**13 Blackwood Place, Bodicote, Banbury, OX15
4BD**

23/03116/NMA

Proposal: The omission of two chimney stacks and insertion of a metal flue. Rooflights at the rear of the property in a different position. A window instead of a patio door at the rear of the property (proposed as non-material amendment to 21/00026/F)

PROPOSED DETAILED ELEVATIONS

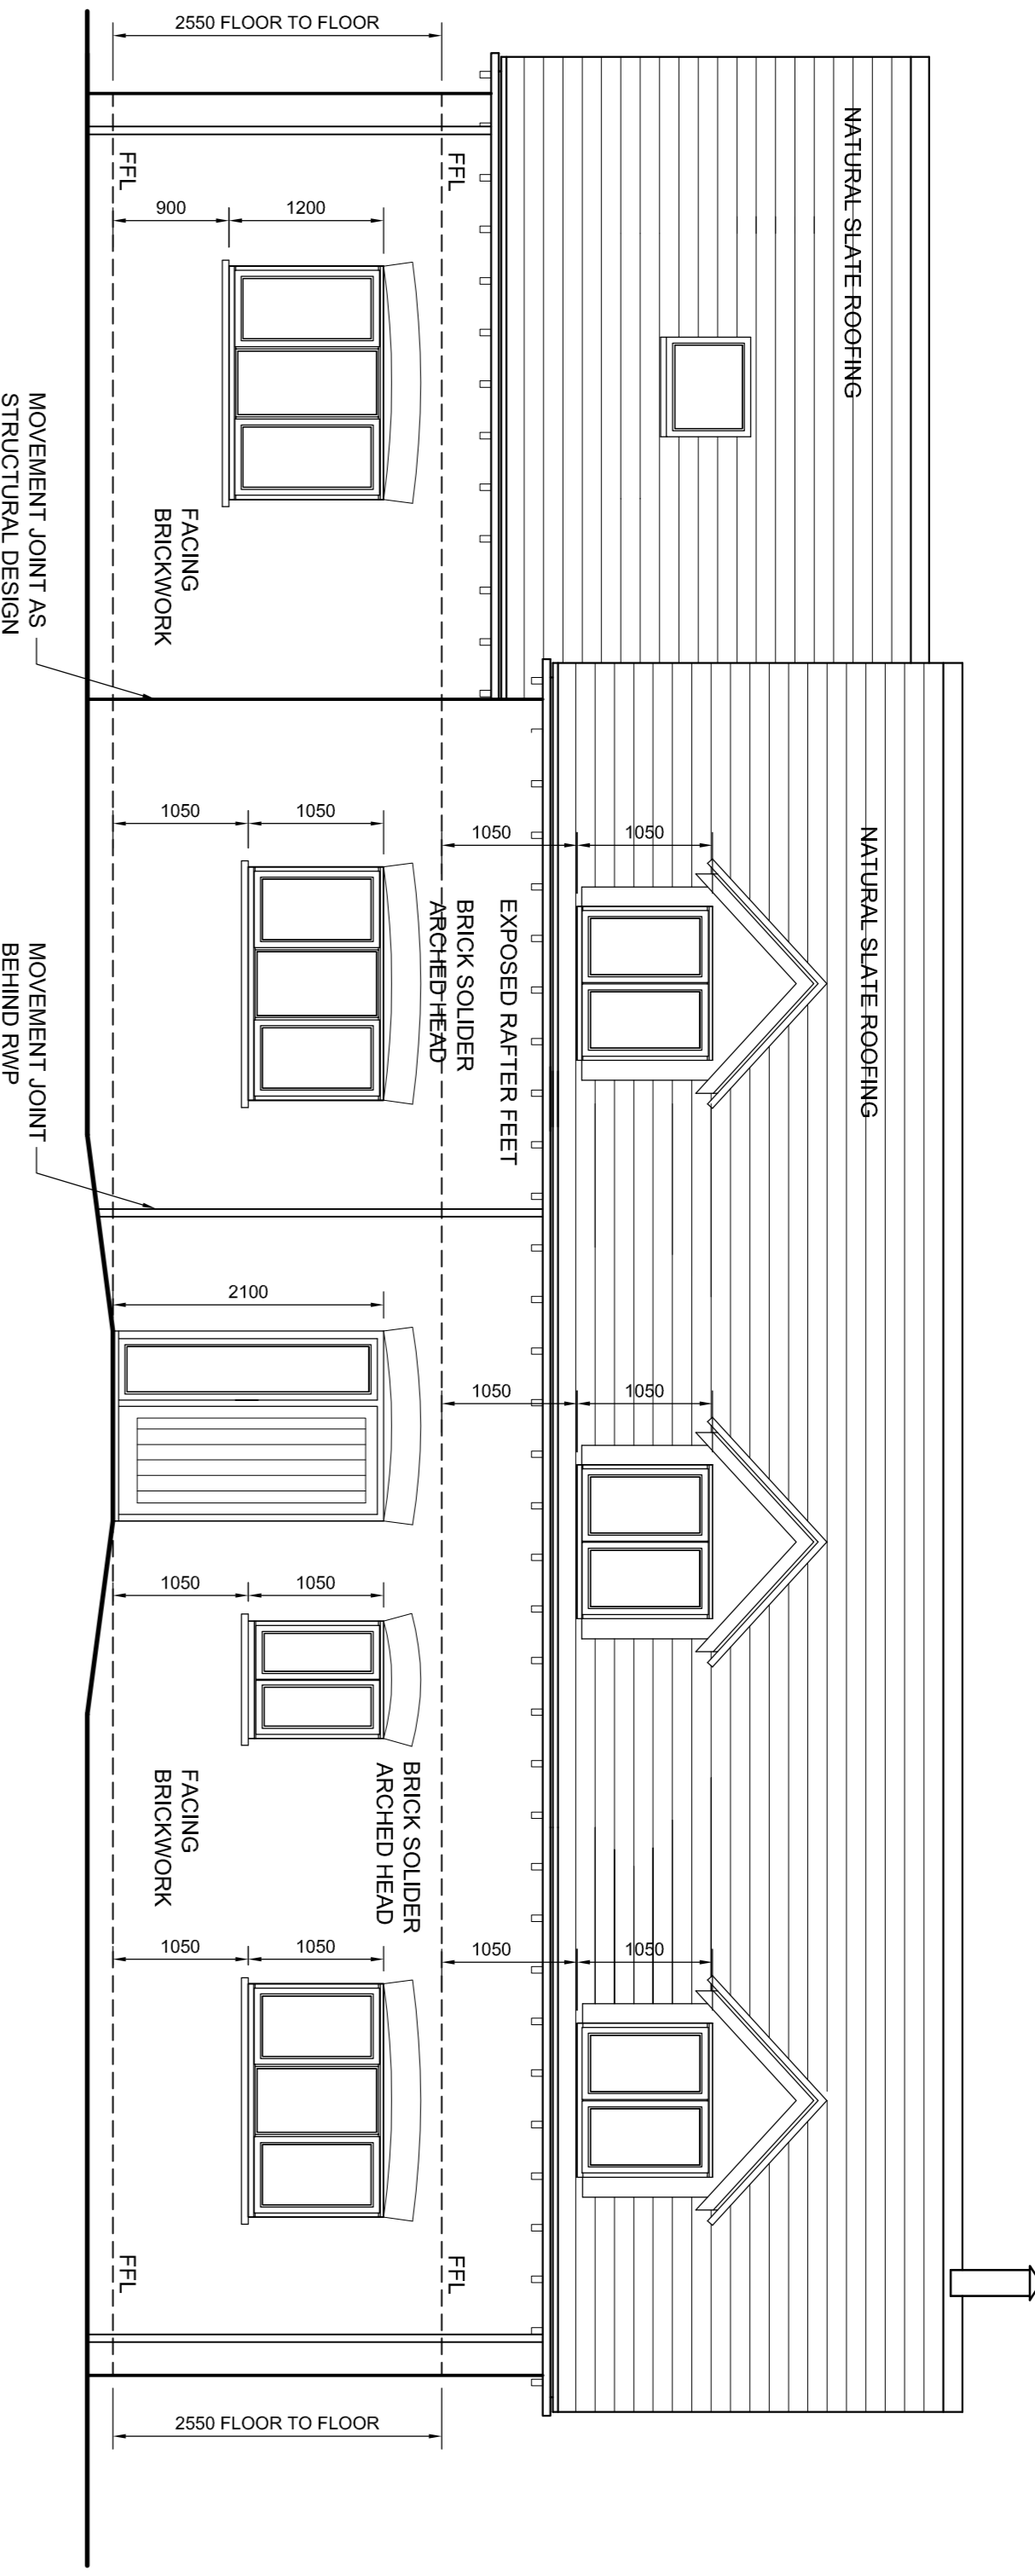
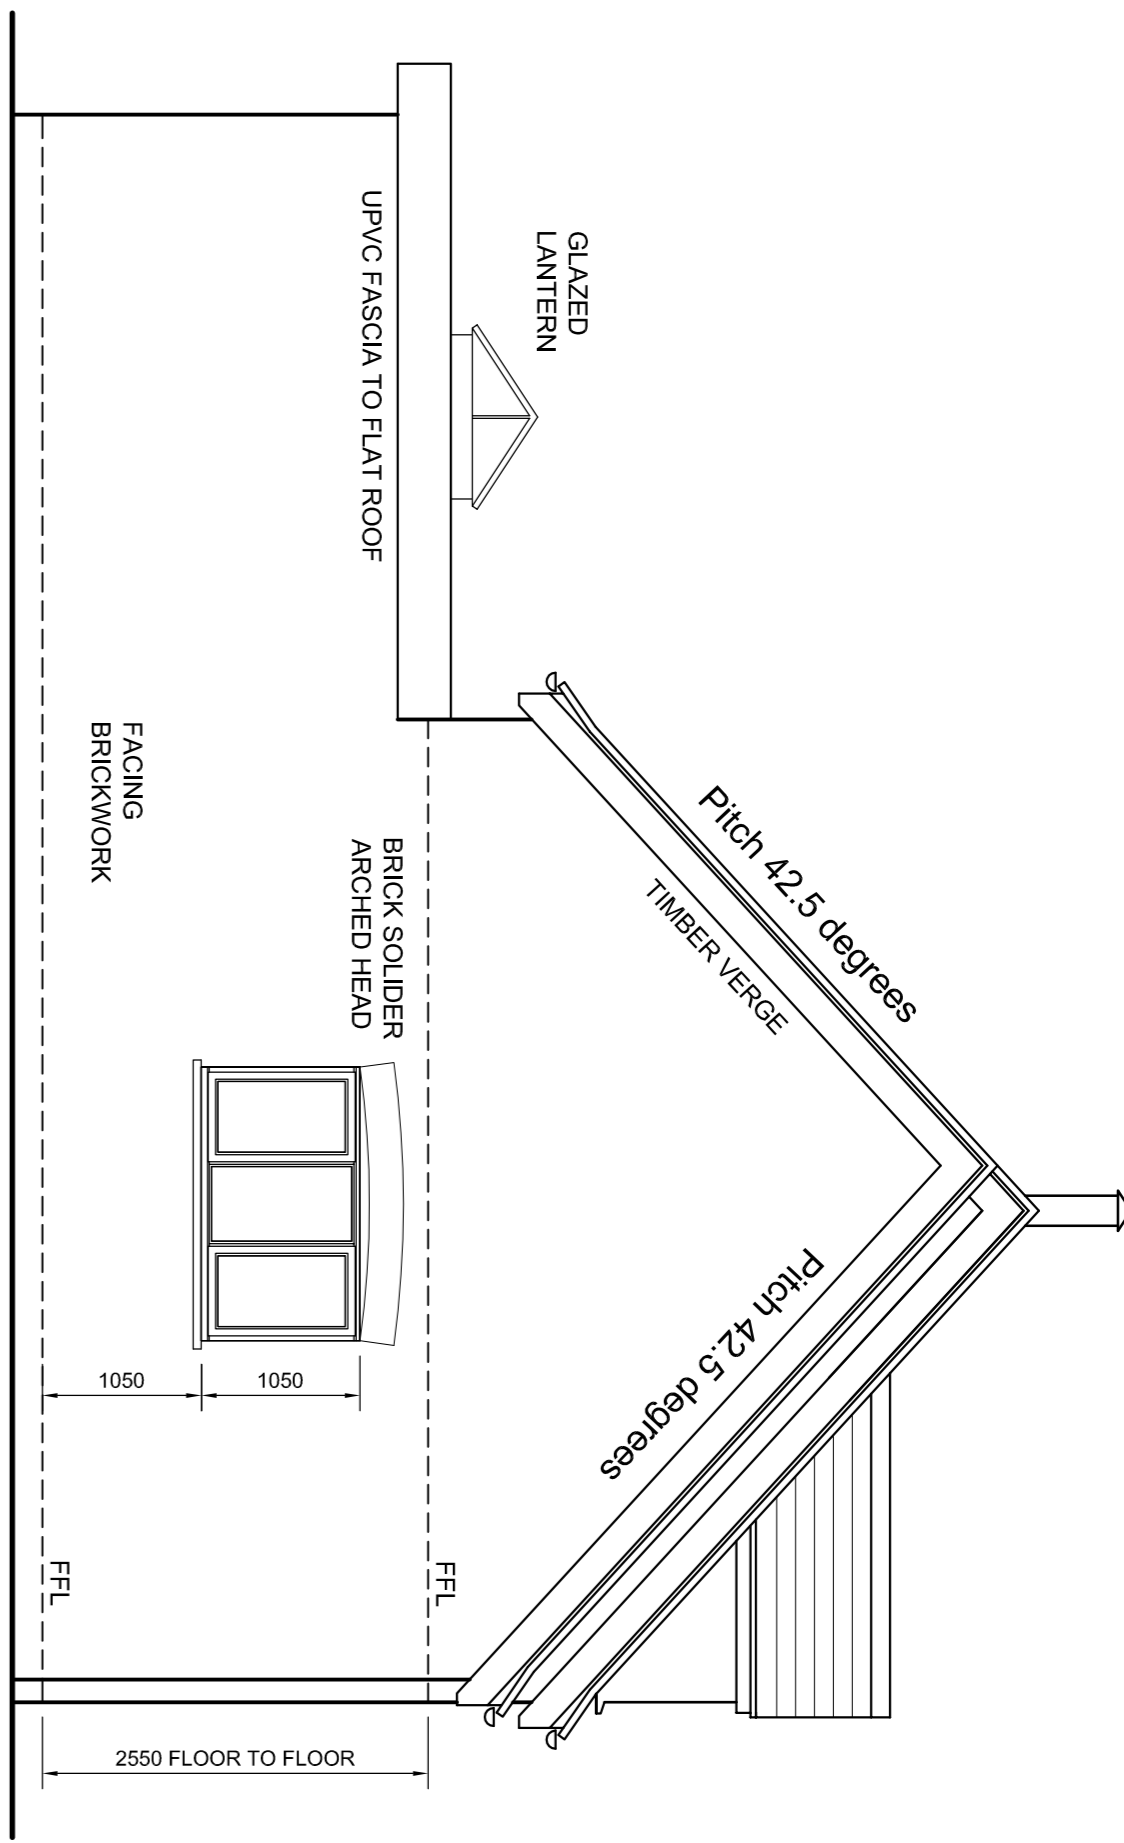
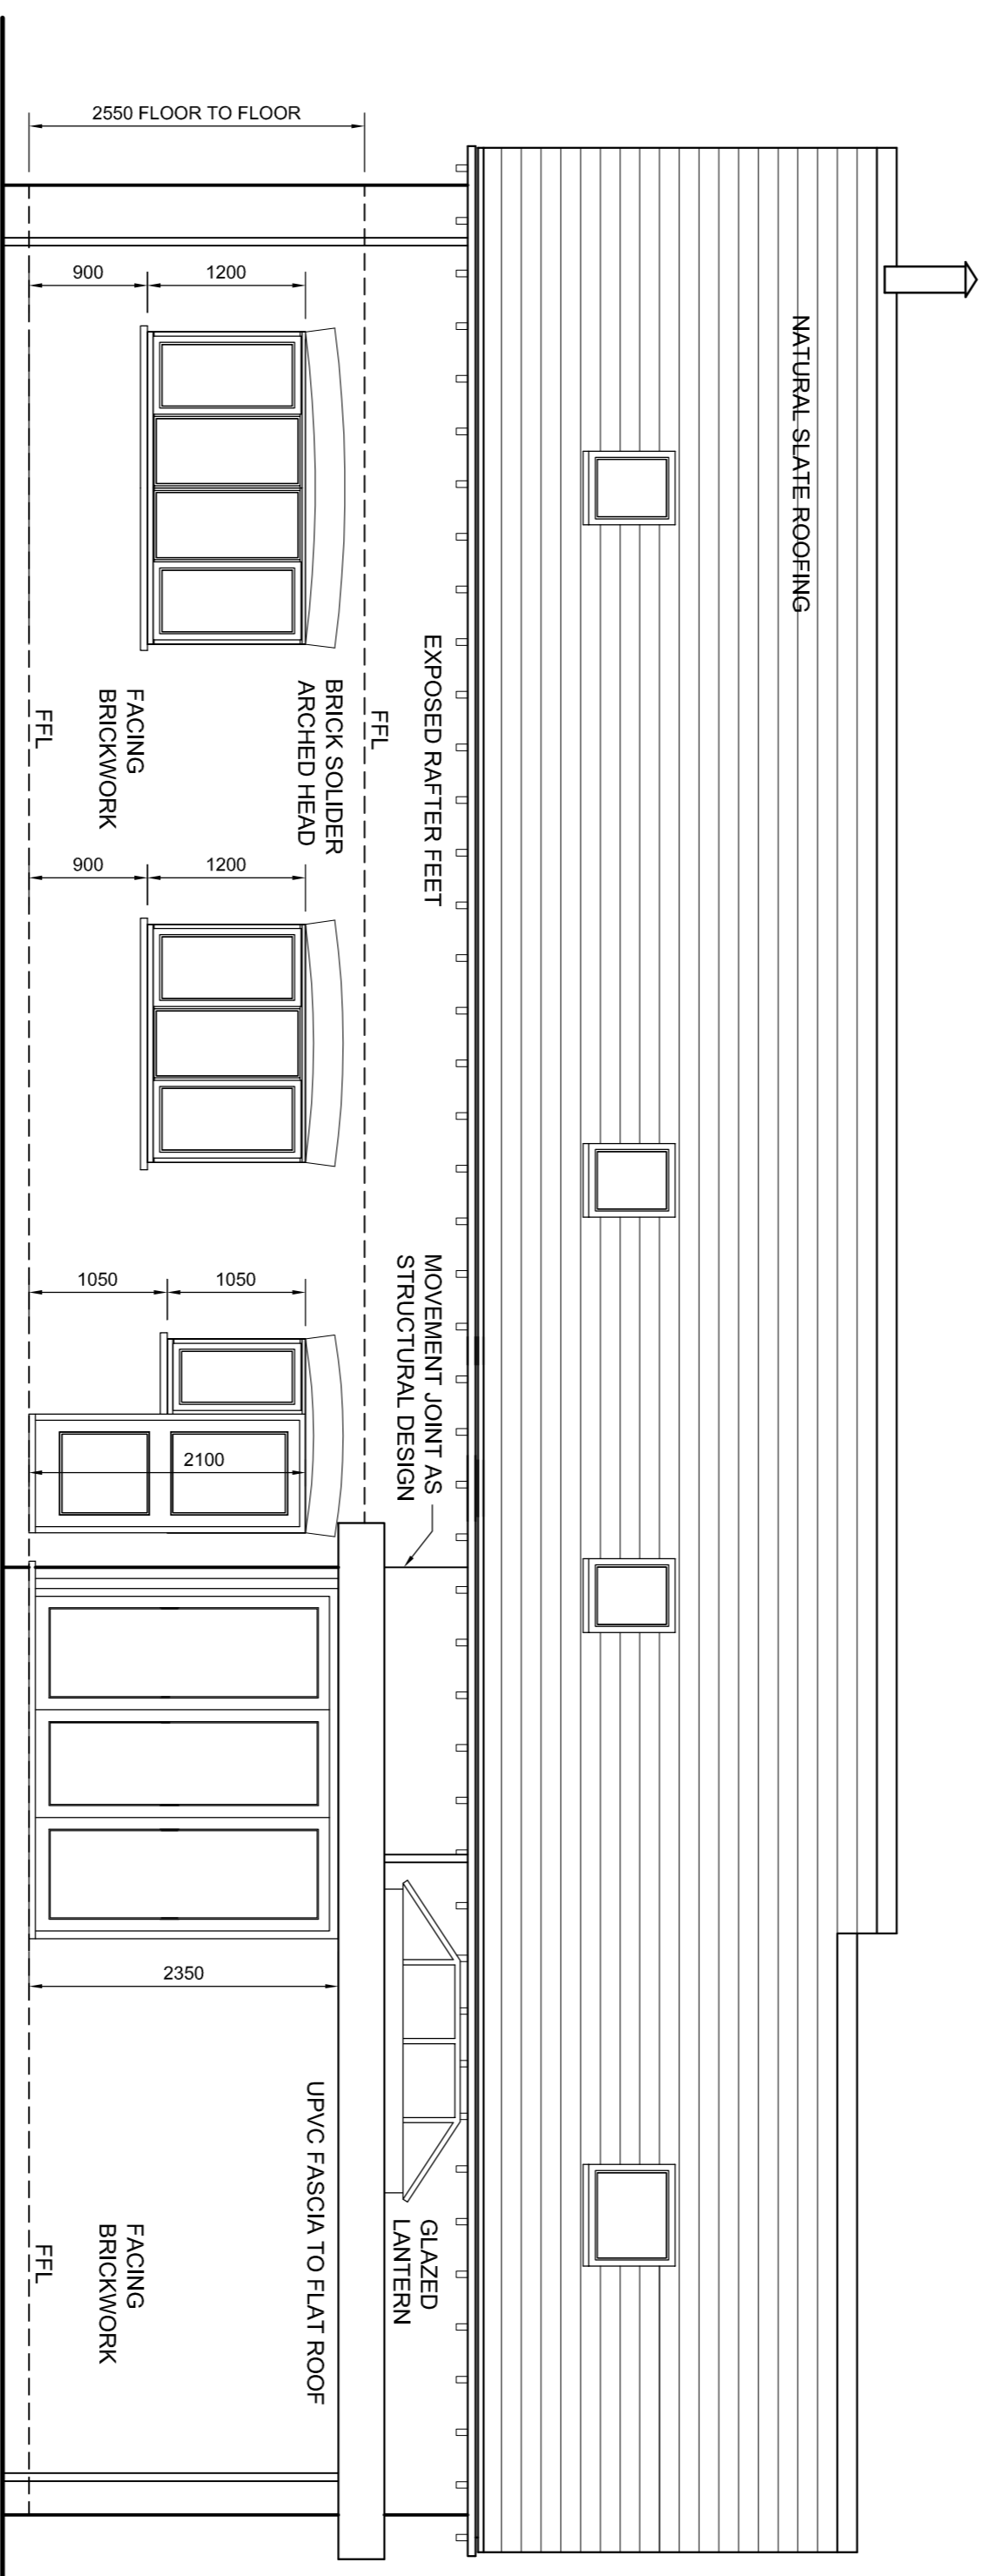
- 2.1. The application seeks consent for changes to planning permission ref. 21/00026/F, specifically to make the following changes:
 - The omission of two chimney stacks and insertion of a metal flue
 - The reposition of the proposed rooflights within the rear elevation.
 - Replacement of a patio door within the rear elevation

- 5.4. The proposed changes would have a visual impact, the most visible changes being the replacement of the chimney stacks with the insertion of the metal flue and the repositioning of the roof lights. The omission of the chimneys would result in some diminution in quality of the development approved under application reference (21/00026/F).

- 5.5. Overall, however, the proposed changes would result in a similar character of development to the previously approved and would not significantly affect the character of the development – particularly given the site’s location outside of a Conservation Area and with the tree screening from the highway, or raise any new issues in relation to the visual and residential amenity.

- 6.1. The proposal is therefore considered to be non-material and the application is therefore recommended for approval.

In accordance with drawing No “03 REV A”
